25 January 2021

**DCO Application for the Aquind Interconnector Project
SDNPA Deadline 7 Submission**

I write to provide the following from the South Downs National Park Authority (SDNPA) at Deadline 7:

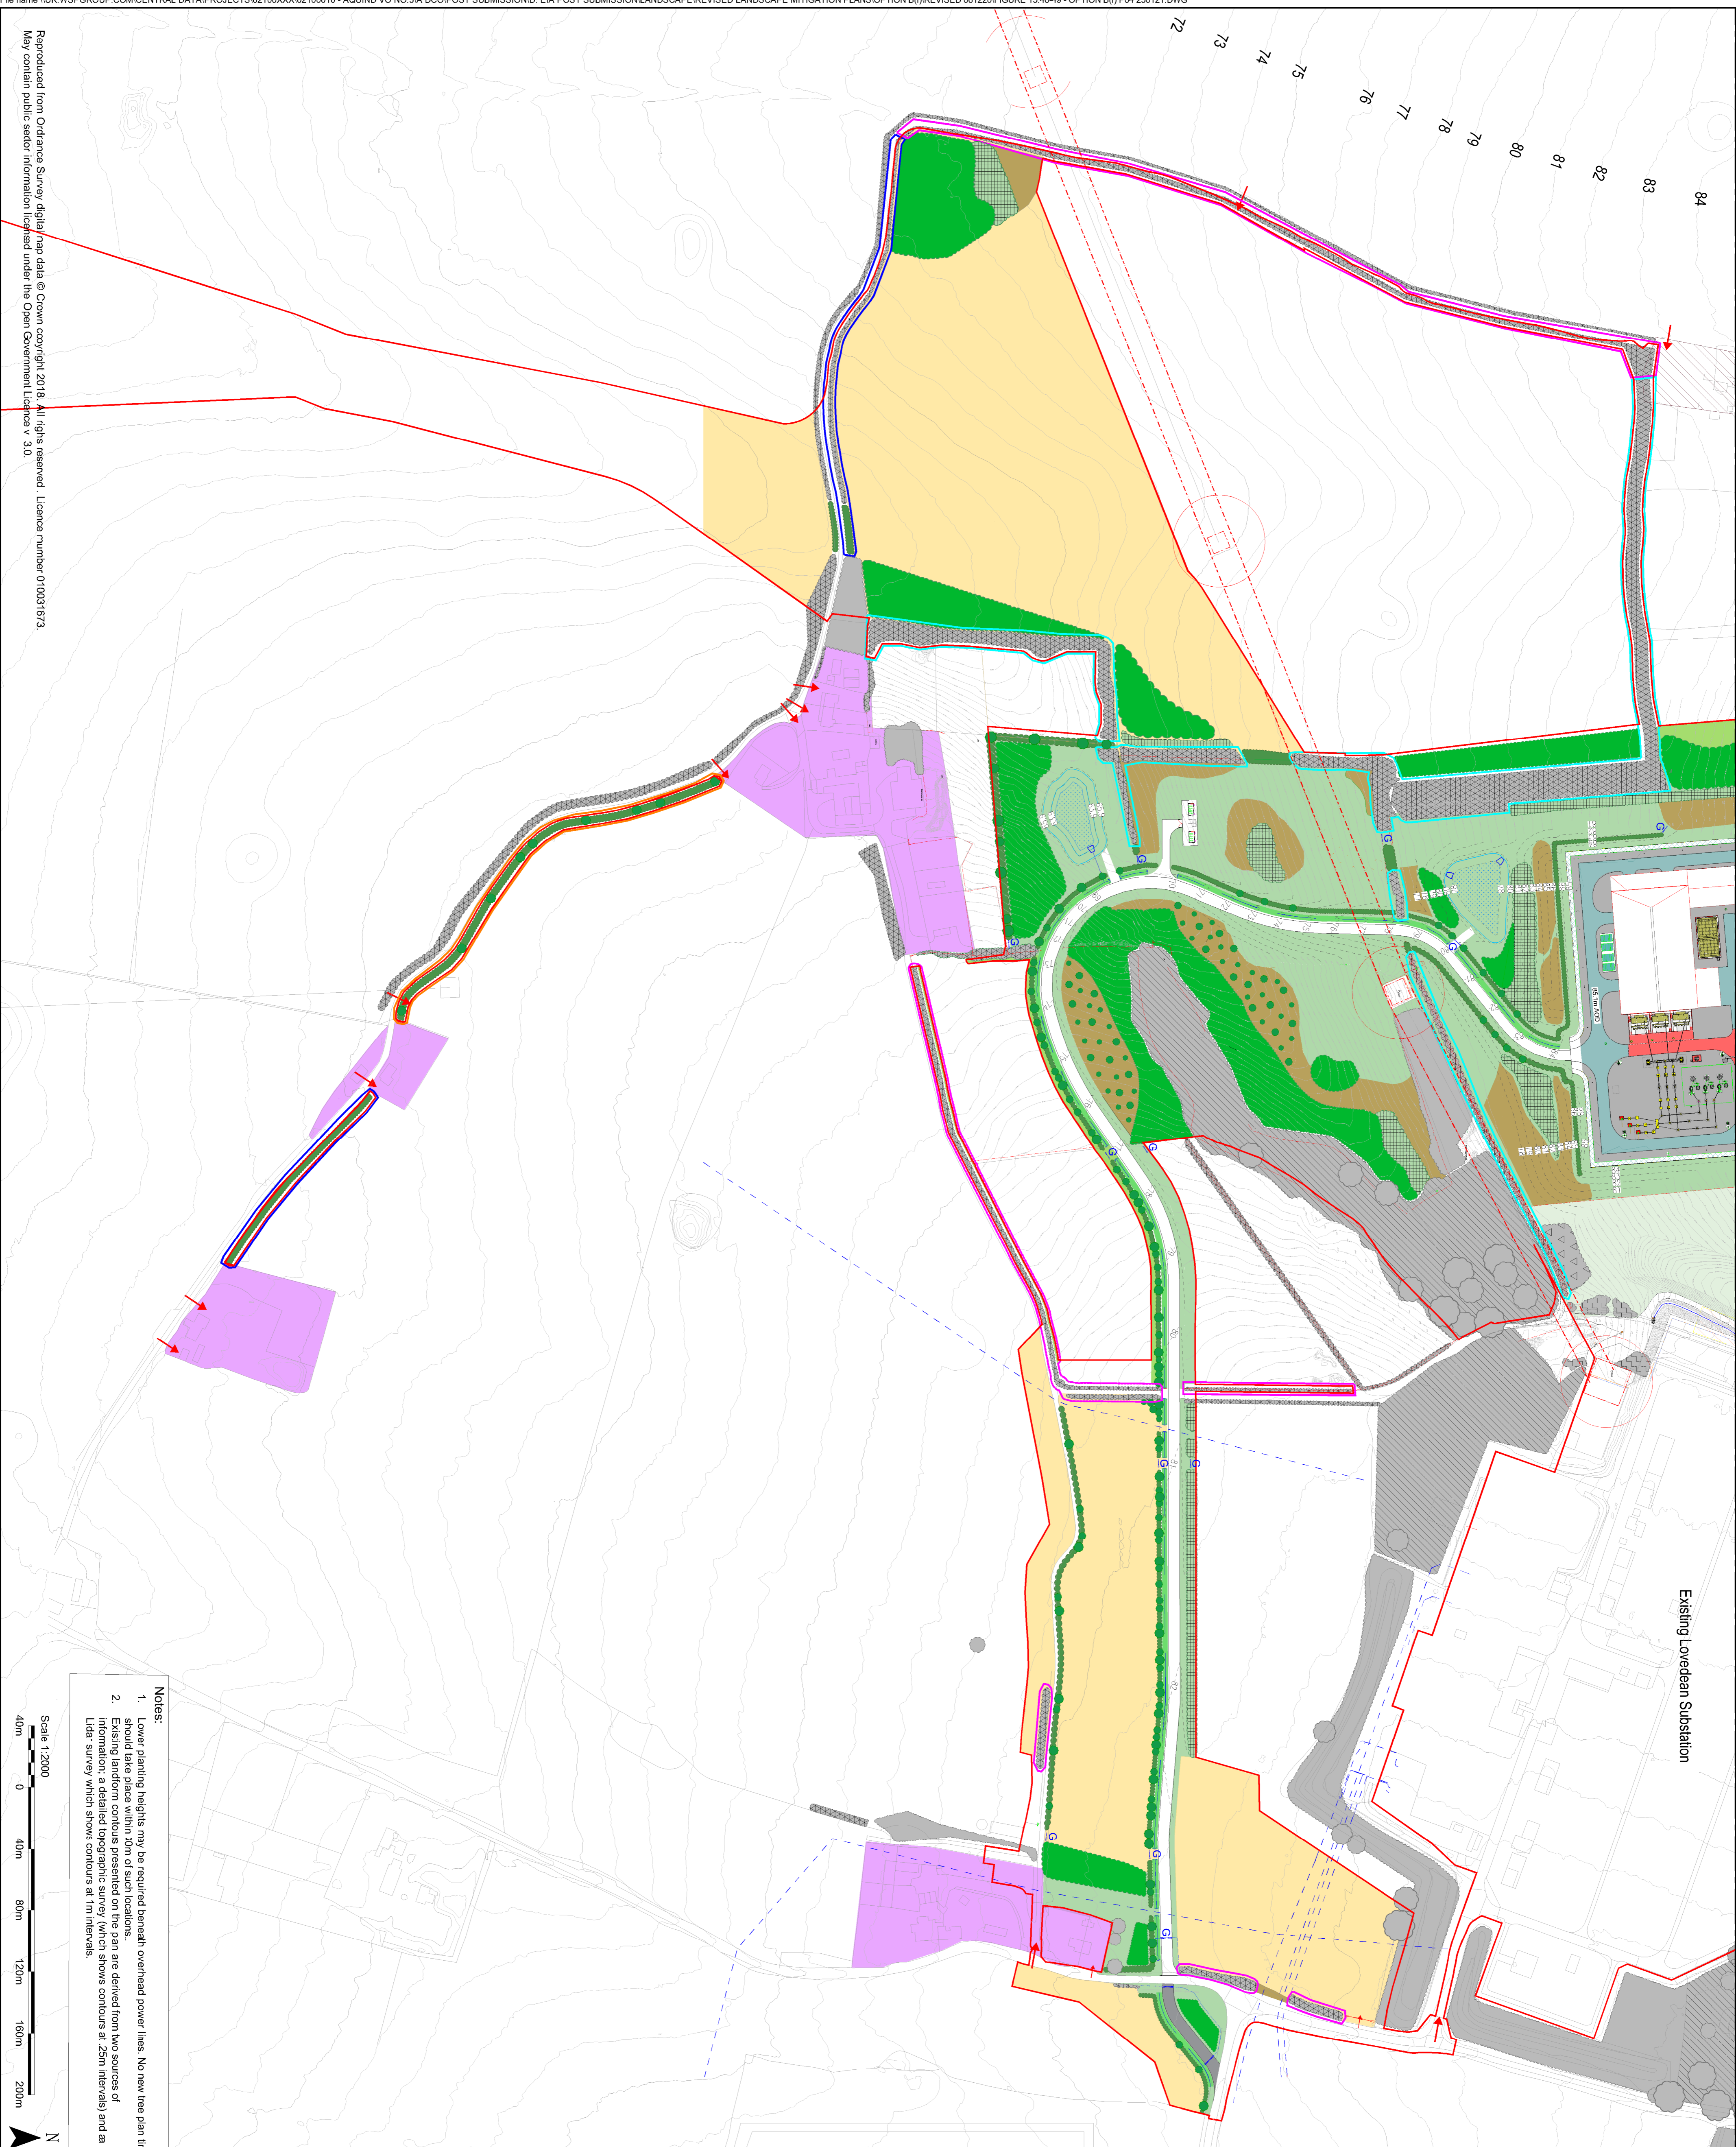
<p>Converter Station site have implications for the results of the EIA, in terms of a future baseline, LVIA and mitigation requirements. Could the Applicant please explain how this supplementary information has been, or will be, integrated into the ES?</p>	<p>the SDNPA we wish to note that whilst there is commentary on the implications of the ash dieback for the assessment of effects, the Environmental Statement has not yet been updated. The SDNPA would welcome the opportunity to review the updated information once received.</p>
<p>HAB2.8.3</p>	<p>Are the proposed woodland management measures to deal with ash die-back in the two ancient woodland copses known as Stoneacre Copse and Mill Copse, as set out in the Applicant's updated Outline Biodiversity and Landscape Strategy submitted at Deadline 6 [REP6-038]:</p> <p>a) appropriate and proportionate; b) capable of being implemented without harming the integrity of the ancient woodland habitats; and c) sufficient to meet visual mitigation requirements against the updated future baseline?</p>	<p>The SDNPA welcome the inclusion of the management measures for the two identified woodlands. We consider that, in answer to question a), the approach put forward is appropriate and proportionate.</p> <p>In respect of b) the SDNPA is not able to comment on the harm (or lack thereof) that may result from the implementation at this stage without seeing more detailed proposals setting out the replanting methodology.</p> <p>In respect of c) the SDNPA recognises that the proposals are likely to meet visual mitigation requirements for these woodlands, but only in the long term with the maturing of vegetation to take the place of the diseased mature trees.</p> <p>The ash die back planting to mitigate visual effects to the south of Mill Copse is indicated on the applicant's revised</p>

Landscape Mitigation plans, however the replacement planting within the existing woodlands, hedgerows and for individual trees is not.
LV2.9.1	<p>The new viewpoint photography provided by the Applicant at Deadline 6 ([REP6-055] to [REP6-057]) is welcome. It is noted that new VP 1b and new VP 2 closely replicate VP 15 and VP 1 in terms of compass direction, but in both cases are from lower elevations.</p> <p>Please could the corresponding elevations (AOD) for the new viewpoint locations be provided so that they can be accurately compared with the elevations provided for VP 15 and VP 1.</p> <p>Please could the Applicant provide visualisations of the Proposed Development on the baseline photographs from new VP 1b and new VP 2, together with an assessment of effects, including any breaking of the skyline by the Converter Station building and structures.</p> <p>Could confirmation be provided that all three magnifications of new VP 2 are at a bearing of 211 degrees, noting that the higher magnification photographs (15.60B and 15.60C) are not centred on the broader, panoramic shot (15.60A).</p>	<p>The photography for the two viewpoints requested by the SDNPA (Prew's Hanger and Days Lane) is welcomed and there are two additional angles of views for the Day Lane access point which is helpful.</p> <p>However, as noted by the Examining Authority the corresponding wire outline images and assessment of effects are not provided to assist a judgement being made on the impacts. The SDNP would welcome this additional information.</p>

Plate 6 - Proposed construction traffic management on Day Lane - will be replaced with full page image when issued as PDF

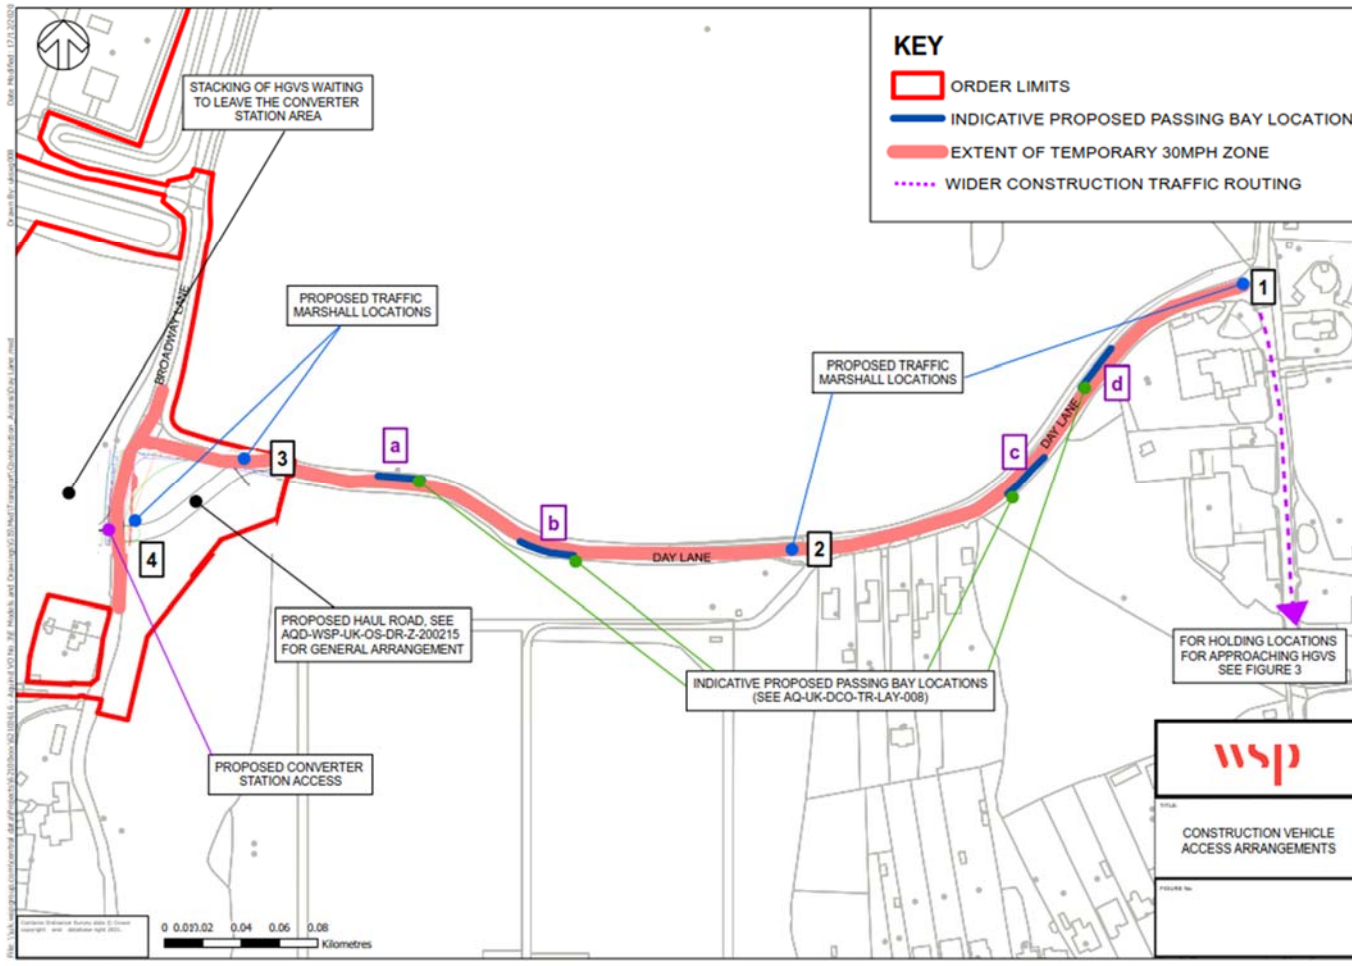
<p>Our boundary mapping shows the National Park boundary running along the edge of the public highway. It appears from Figure 2 of the applicant's Day Lane Technical Note (examination library reference REP6-073) that the passing bays may be located within the existing highway boundary (and thus outside of the South Downs National Park) but we would appreciate the applicant's confirmation on this point.</p>
--	--	---
